Date: 23 March 2018
Your Ref: A/11/OUT and A/23/15/OUT
Our Ref: 9349

OBJECTION TO APPLICATIONS A/11/17/OUT AND A/23/15/OUT RELATING TO LAND SOUTH OF NEW ROAD (A259) AND EAST OF BROOK LANE ANGMERING

The purpose of this letter is to outline the outstanding concerns that we have in respect of transport and highway matters on both of the applications. We would be very keen to discuss these in detail with you; however, we hope that this letter will provide you with a helpful summary of our outstanding concerns.

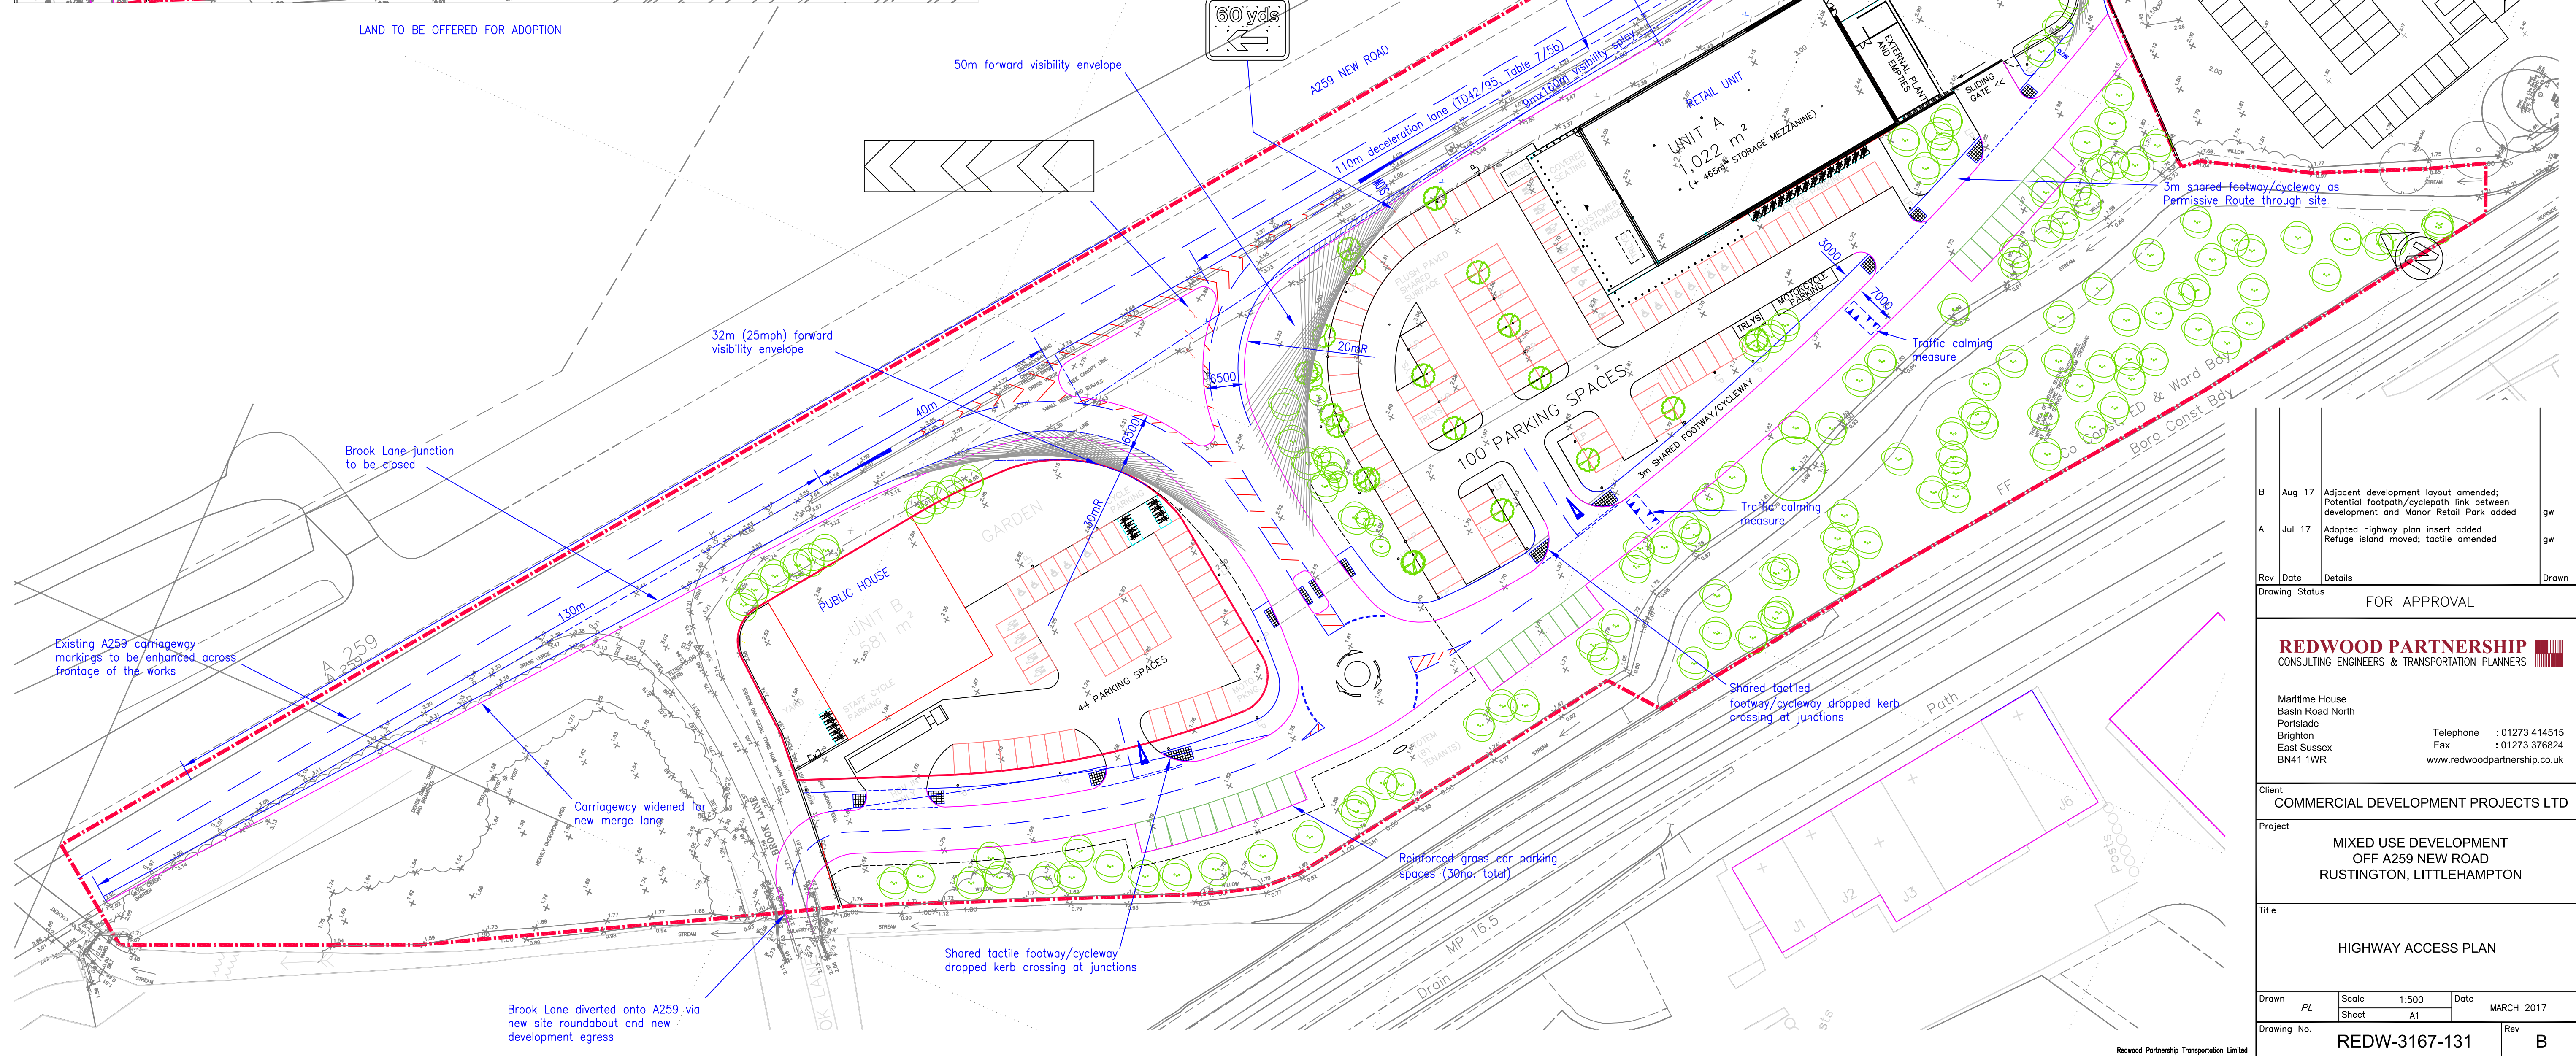
The advice from WSCC is that they would not adopt the internal roads. SDB’s access plan (REDW-3167-131B) therefore needs to be updated as it currently states that the routes would be ‘offered for adoption’. Either the scheme needs to change prior to determination to ensure that adoption is a realistic probability, or the applicants should ensure that the implications of their design are properly understood. In particular, we consider that the access proposed would not be suitable for the residential scheme which is a committed development. A residential scheme of the size proposed on my client’s site would need a road built to the boundary which was at the very least built to adoptable standards. If the road is not going to be adopted, this is likely to reduce the attractiveness of the site to residential developers and therefore threaten the delivery of new homes which would make a valuable contribution to the Council’s housing land supply.
